# THA Architects, LLC

March 13, 2018

Re: Plan Examination  
Midtown Building 2 – 8 Story Parking structure with Mixed use space  
59 Somerset Street  
Portland, ME 04101

As a follow up from our initial response letter dated March 8, 2018, please find the following to be additional information provided by the MEP/FP engineer. Only the Mechanical Plan Reviewer, Plumbing Plan Reviewer and Electrical Plan Reviewer comments are addressed herein. The additional responses provided are in bold text for ease of review. Feel free to contact me if you have any questions.

E-1.1

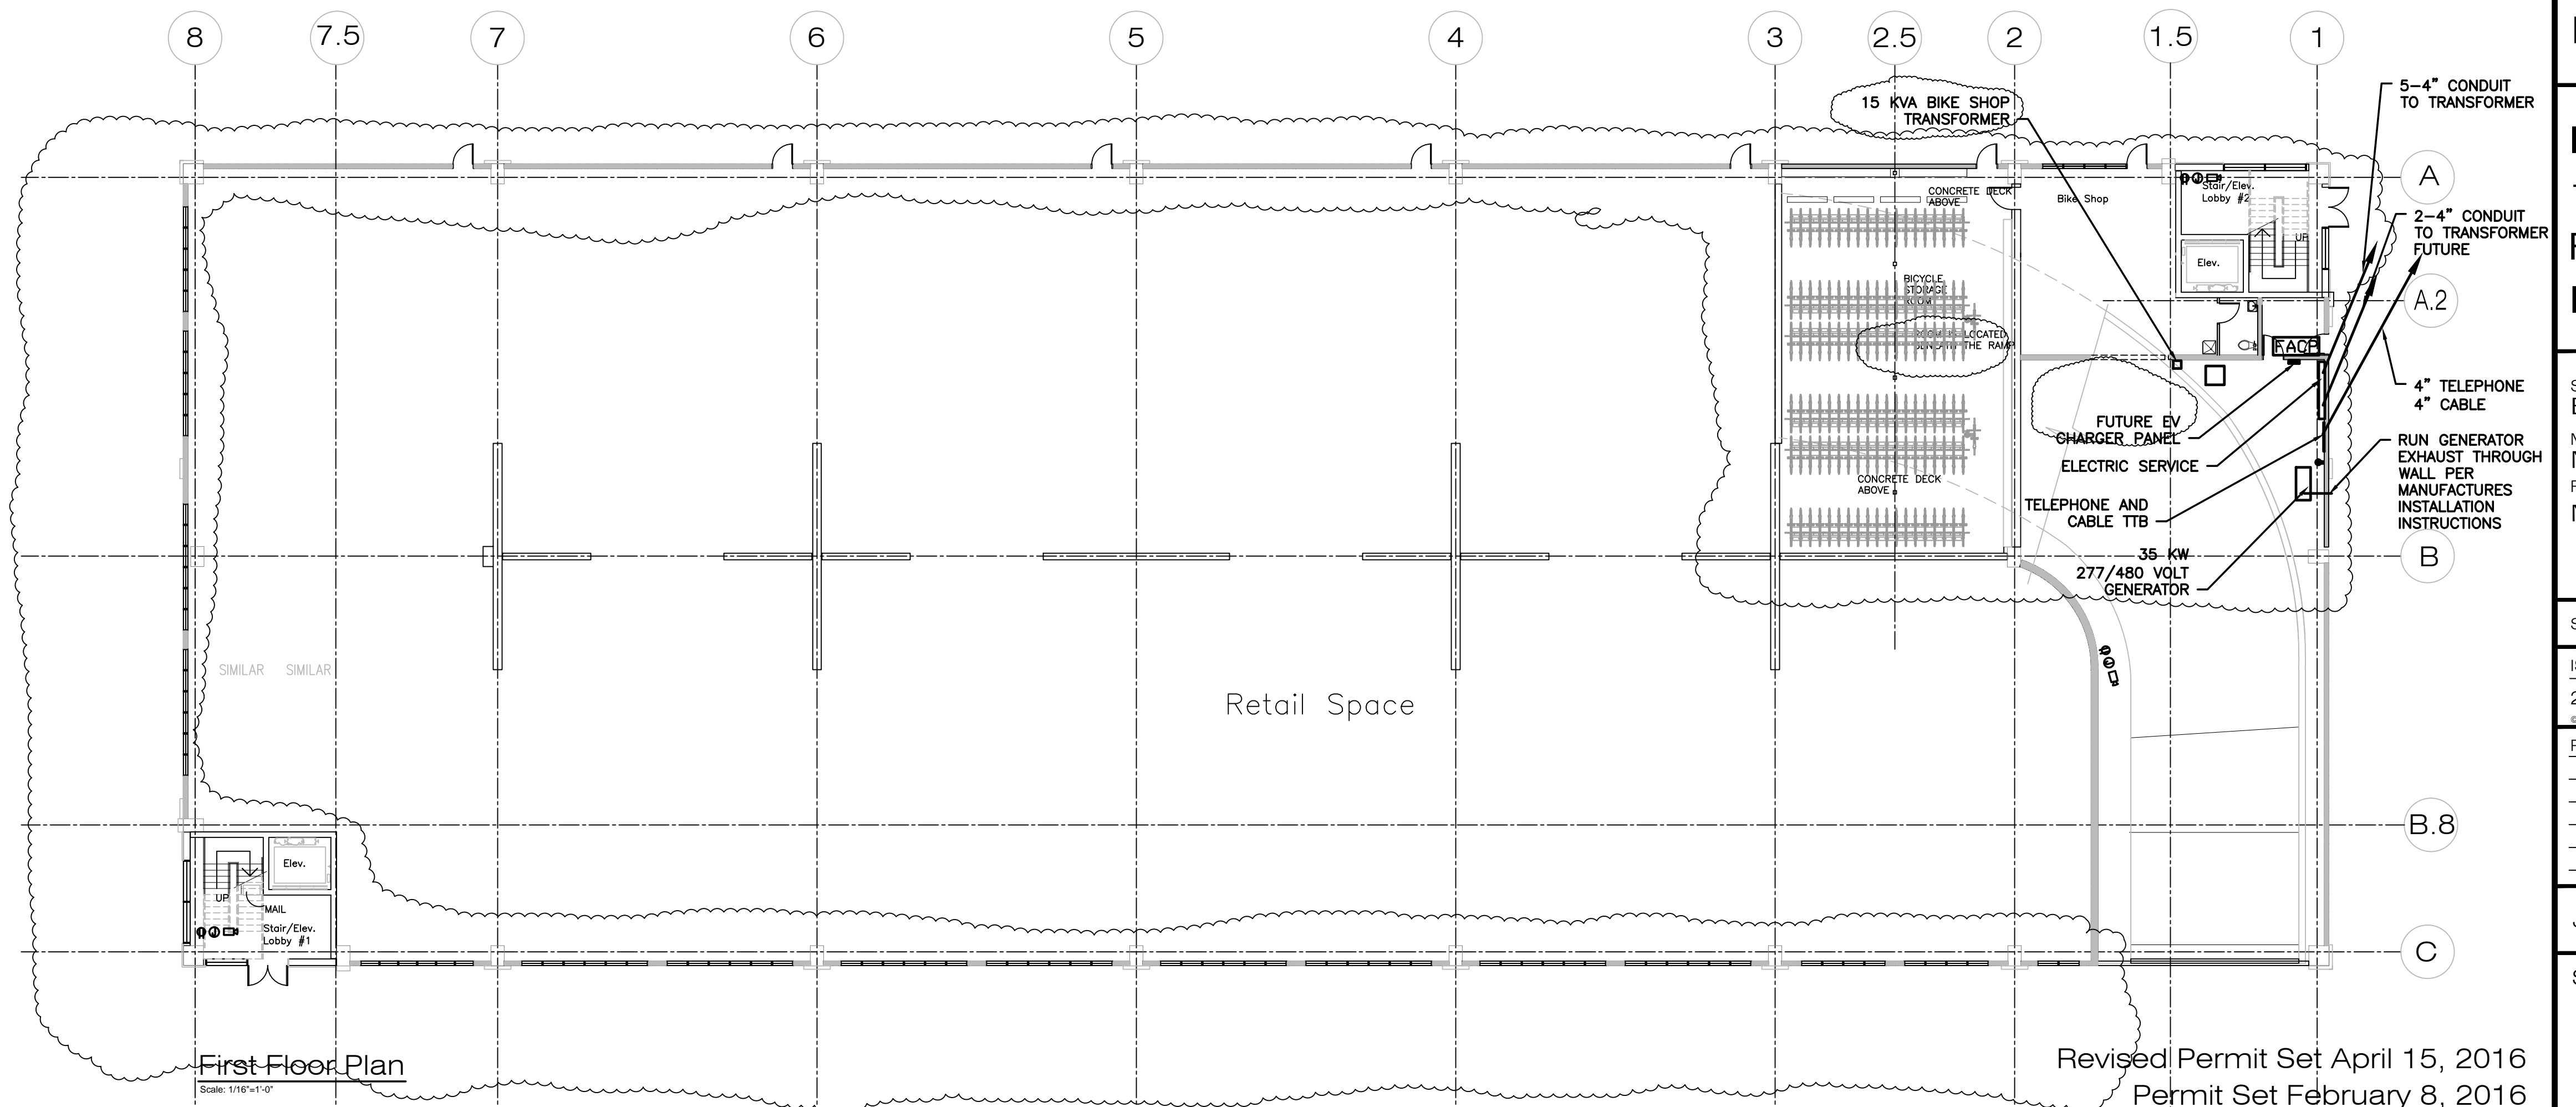
- In regards to the GFI outlets, please refer to sheet E-1.1 and E-2.1, both dated March 8, 2018, for location of GFI outlets provided.
- The location of the pad mounted transformers is the responsibility of the civil engineer. Refer to civil drawings for additional information as provided by the Applicant. **No additional responses are provided for this item.**

SHEET NUMBER
E-3.1

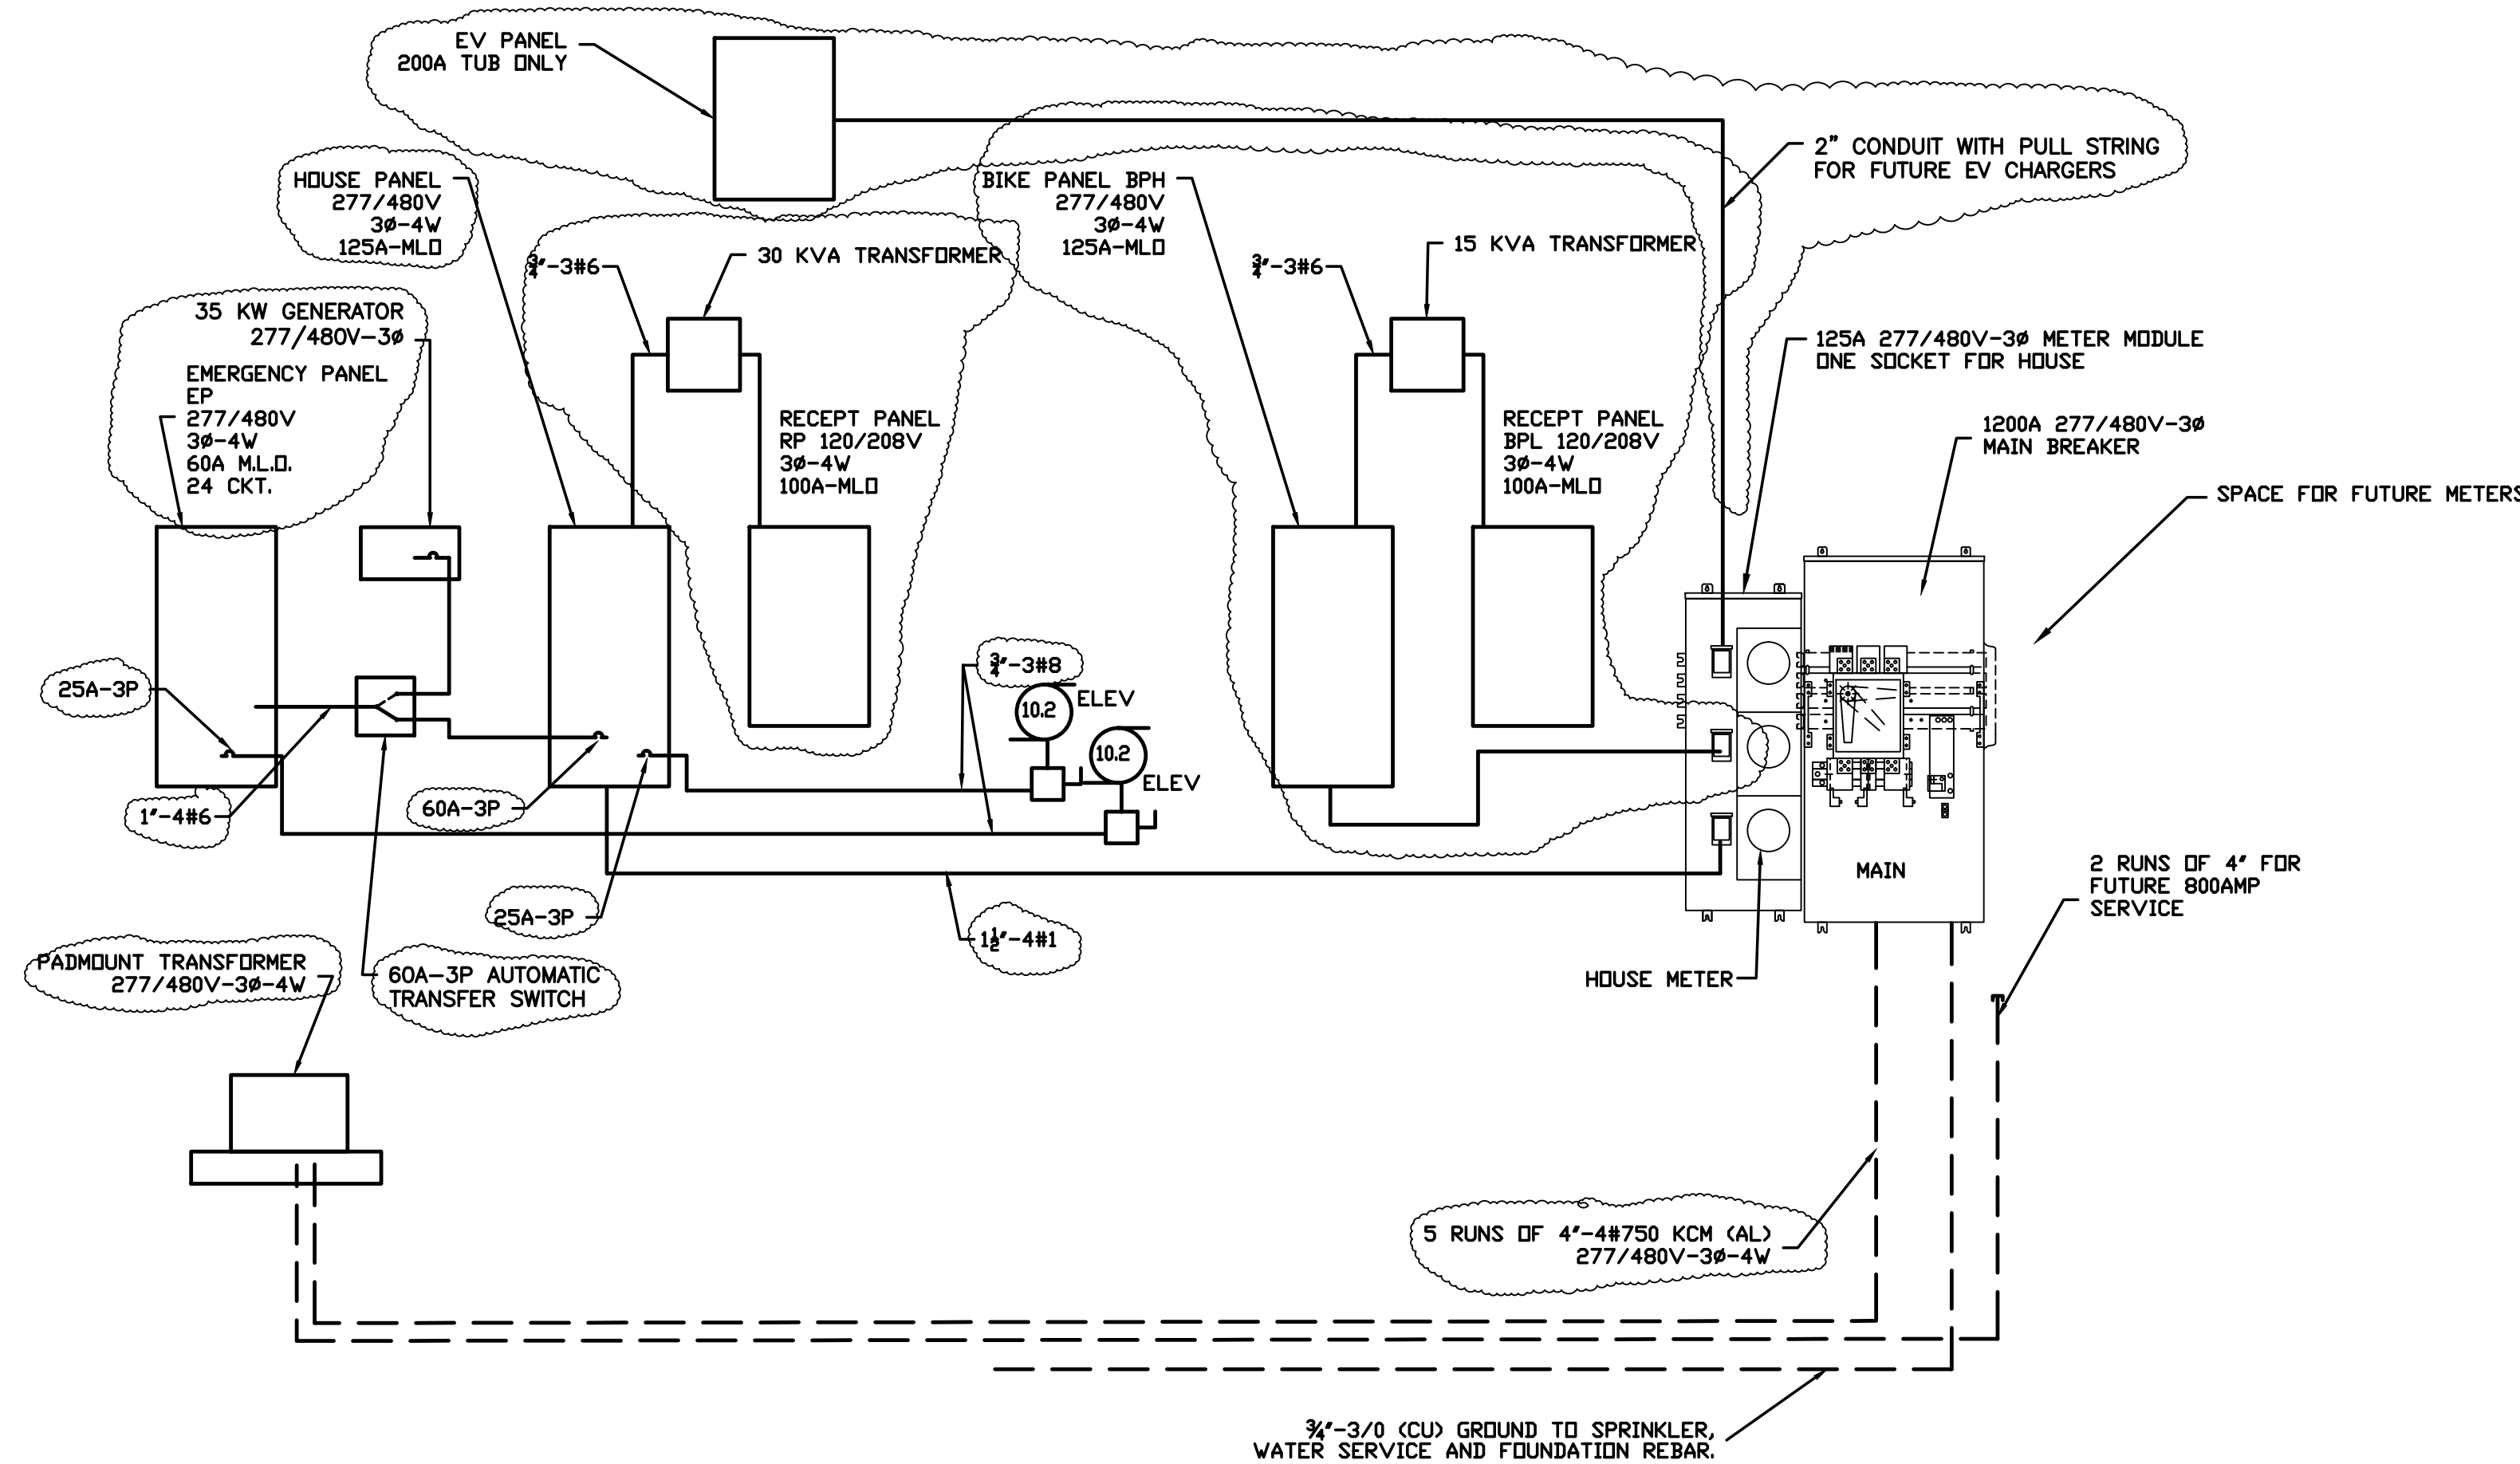
- E-3.1 – House Panel HP power requirements have been revised to accommodate new light fixtures. Removed Emergency Panel EP as emergency generator is not required.

**(H) EXTERNAL GREASE TRAP DESIGN**  
N.T.S.

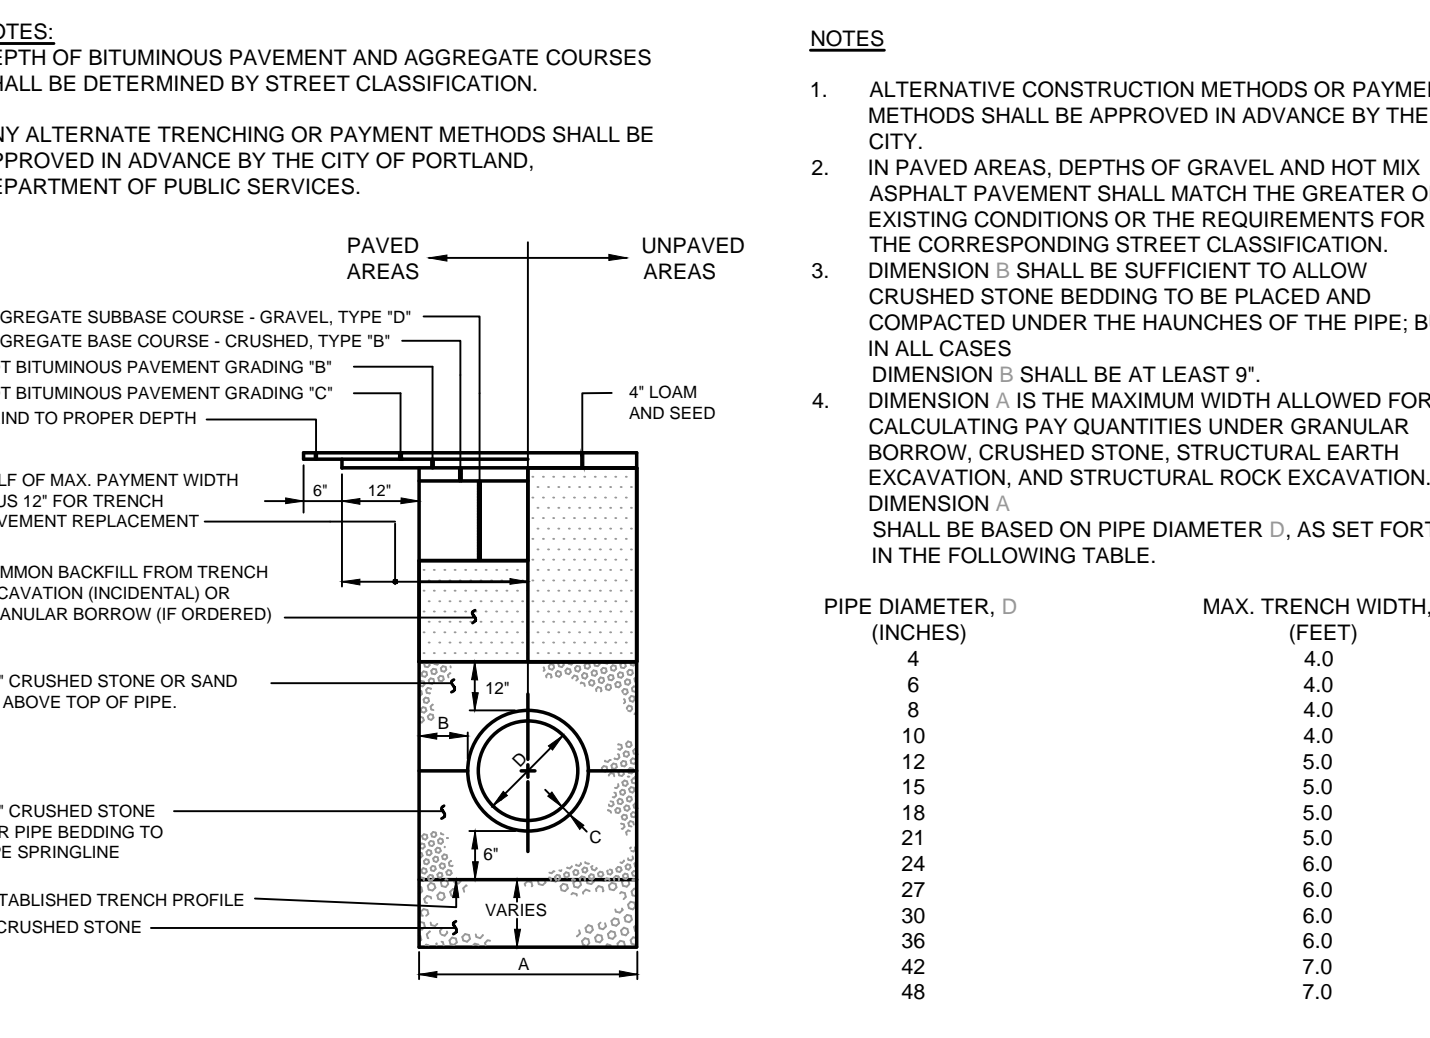
- Piping details for piping into and around the grease traps is the responsibility of the civil engineer. Refer to civil drawings for additional information as provided by the Applicant. **No additional responses are provided for this item.**

- Grease trap or oil separator details are the responsibility of the civil engineer. Refer to civil drawings for additional information as provided by the Applicant. **No additional responses are provided for this item.**
